**Modification 4 Design Development Application for Sydney Modern - SSD 6471**

Thank you for your referral dated 16 November 2020 inviting comments from the Heritage Council of NSW on the above State Significant Development modification proposal.

**Steven Meredith**  
Regional Manager,  
South  
Heritage NSW, Department of Premier and Cabinet  
**As Delegate of the Heritage Council of NSW**  
1 December 2020

Figure 12. Proposed landscape plan of the Gathering Space and Crescent Hill under the Proposed Modification
Source: Gustafson Guthrie Nichol (GGN) Landscape Architects and McGregor Coxall Landscape Architects

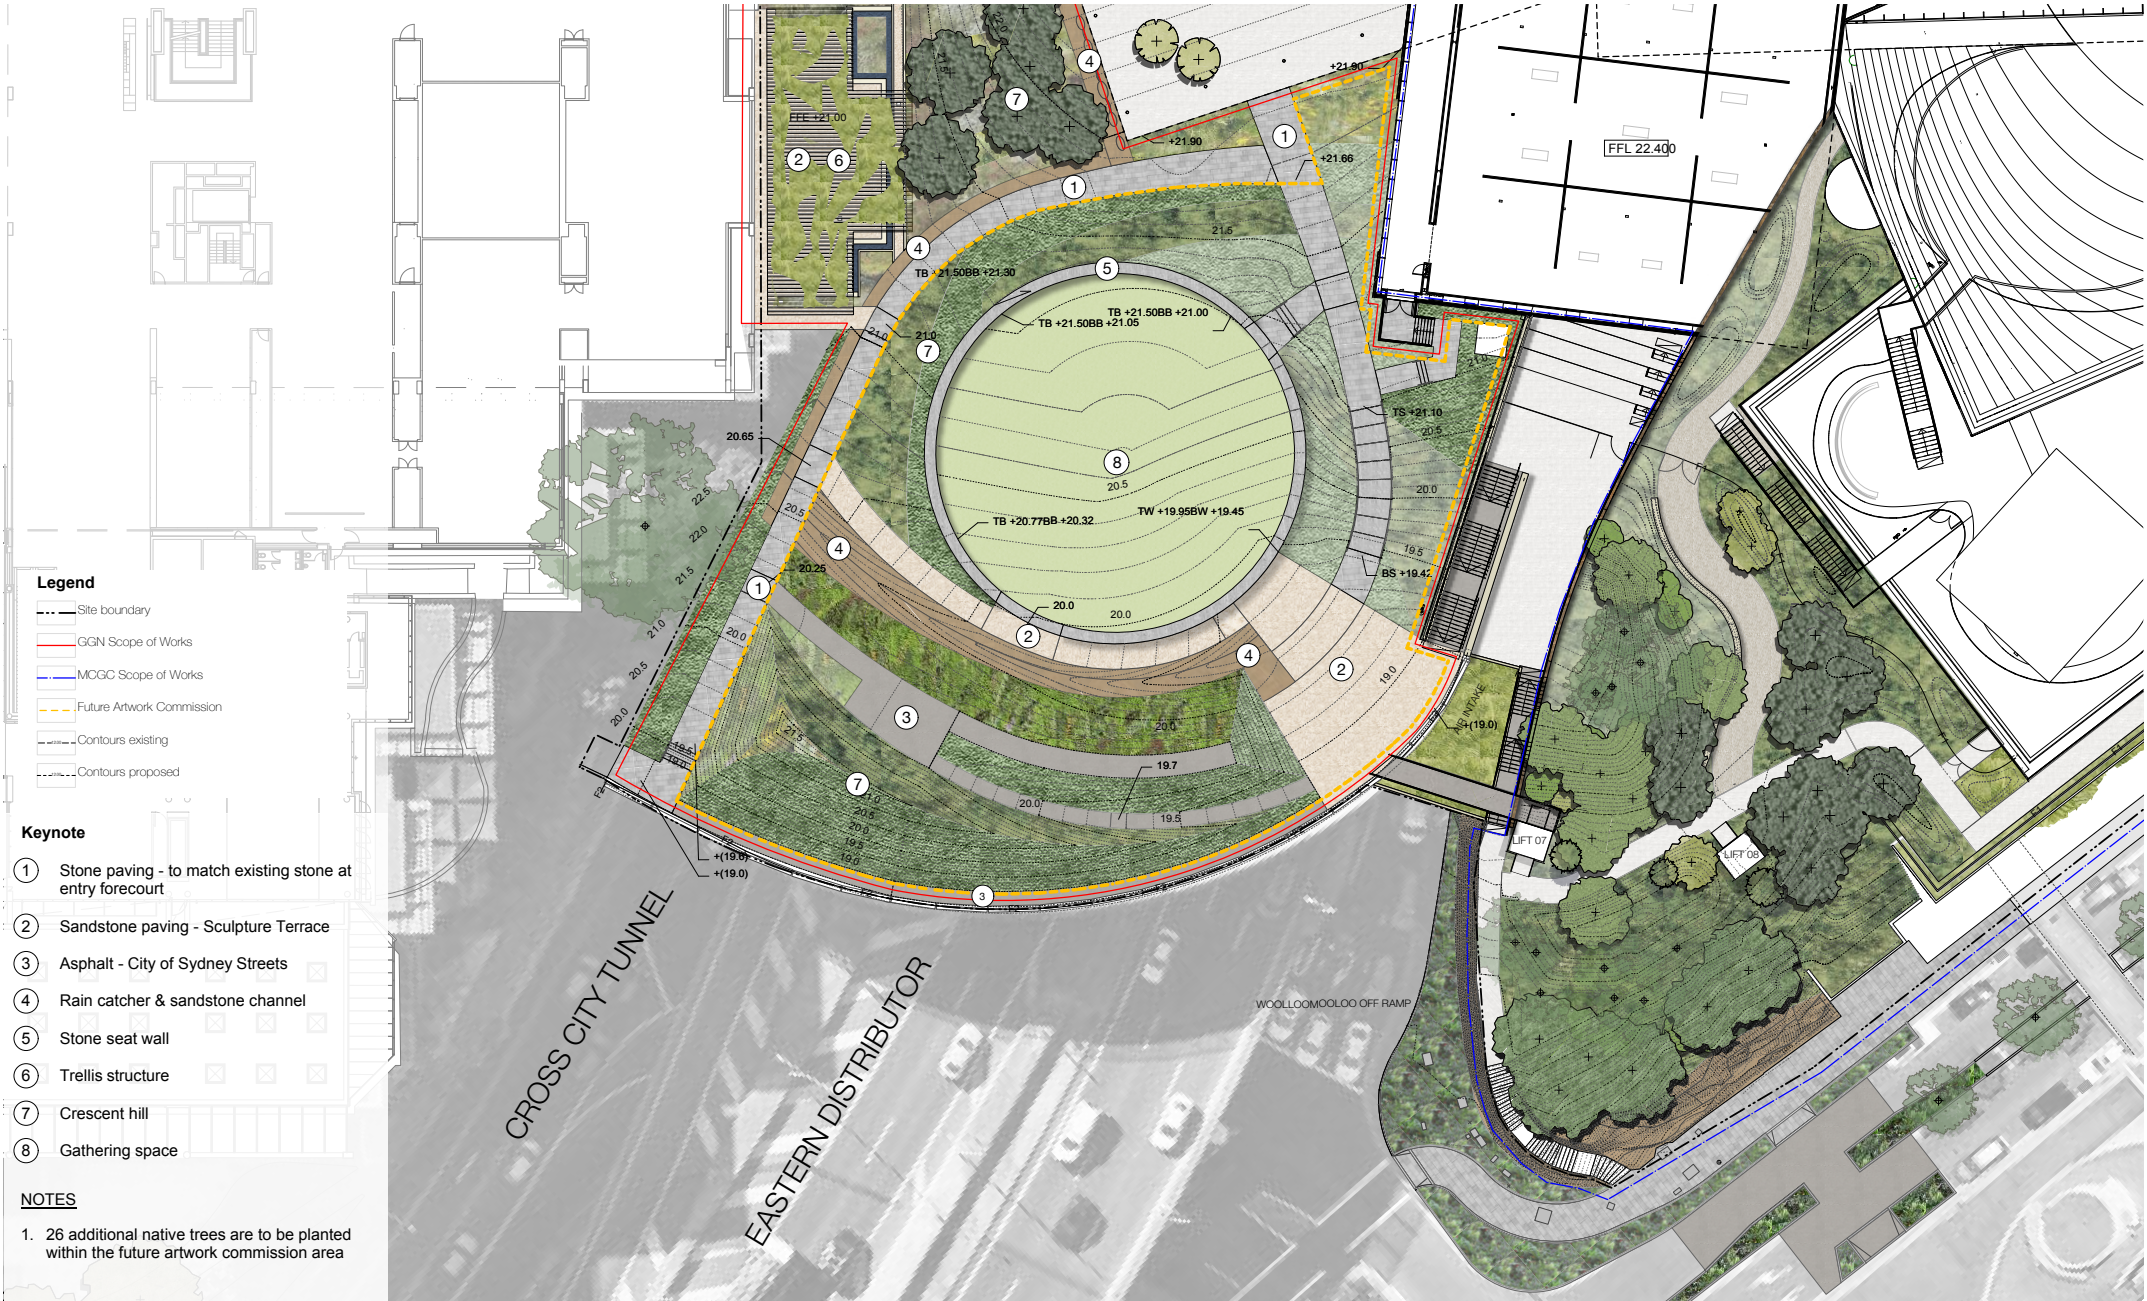
7. The large circular open area referred to as a gathering space has effectively been converted into an informal amphitheatre. While the public seating areas are considered acceptable, further consideration should be given to the extent of designed landscaping and its impact upon the symmetric formal geometry of the Vernon curtilage. Details of the design should be prepared in consultation with the heritage consultant to ensure that the landscape reflects the extension and aesthetic of the RGB&D.
